From: Ed Britton [Ed.Britton@glhearn.com]
Sent: 02 December 2013 13:50
To: Thames Tunnel
Subject: Tideway Tunnel - Objection Letter [FORE Advisors LLP] 021213
Follow Up Flag: Follow up
Flag Status: Orange
Attachments: FORE - tideway tunnel letter - 2013dec1.pdf

Section 102A Planning Act 2008
Application by Thames Water Utilities Limited for the Thames Tideway Tunnel
Written Representation WW01001 TTL-A005

FORE Advisors LLP (acting for FORE UK 1a LP and FORE UK 1b LP) own a long leasehold interest in 58 Victoria Embankment, formerly known as Audit House, which is located between Telephone House (Grade II listed) and Carmelite House. Our property is located within the Whitefriars conservation area.

**Figure 1.1 Blackfriars Bridge Foreshore: Site context and location plan**

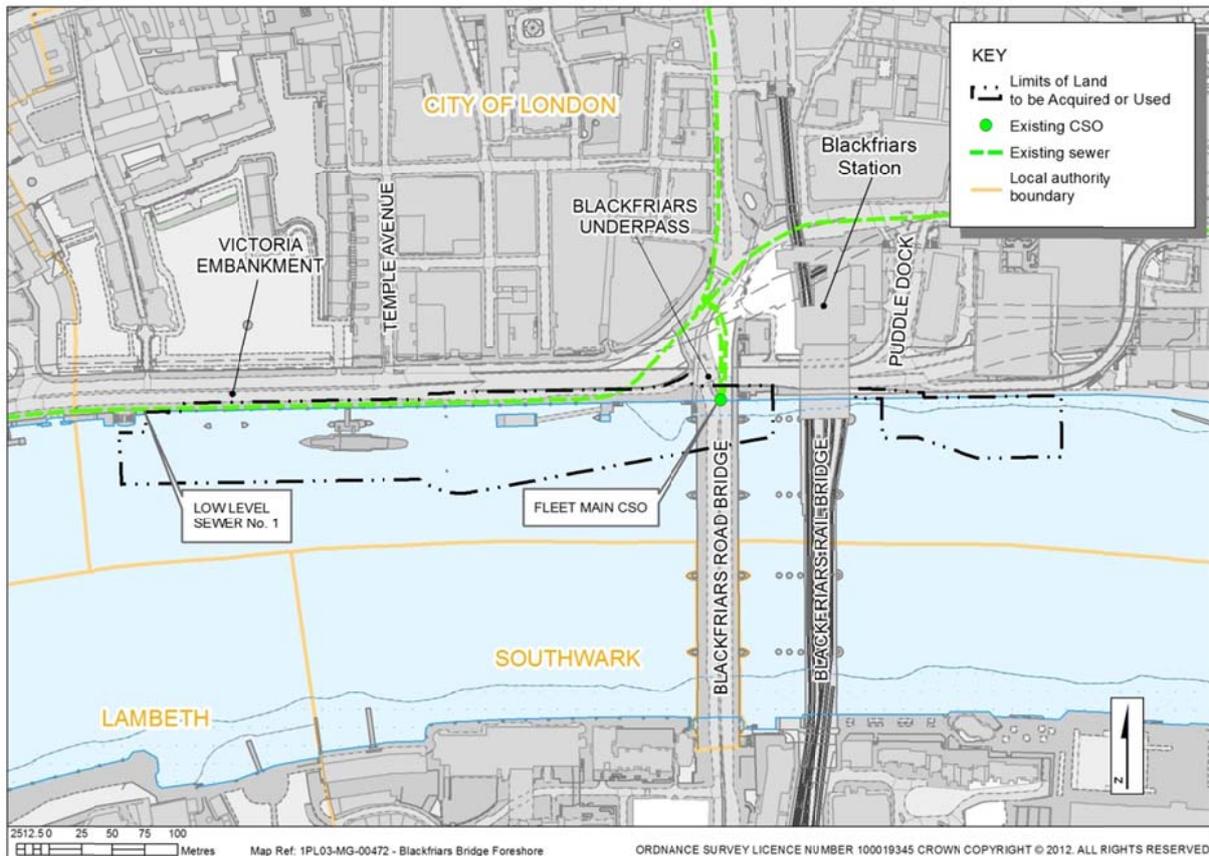
Whilst we do not dispute the assertion that the impact of the foreshore works are mitigated as the works are set below the embankment wall, we consider this is not the case with regard to the ventilation columns which are identified in Figures 1 and 2 attached as Appendix 1.

These columns are 5m in height and as can be seen in Figure 2, the flues project high above the wall. Therefore the statement that the design of the structure would allow unhindered views from the listed buildings is incorrect. There will be an impact on the Whitefriars Conservation Area, the view from Waterloo Bridge and from Blackfriars Bridge and Gabriels Wharf.

In order that the aforementioned views are not affected, it should be recommended that the height of the ventilation columns do not exceed the height of the Embankment wall.
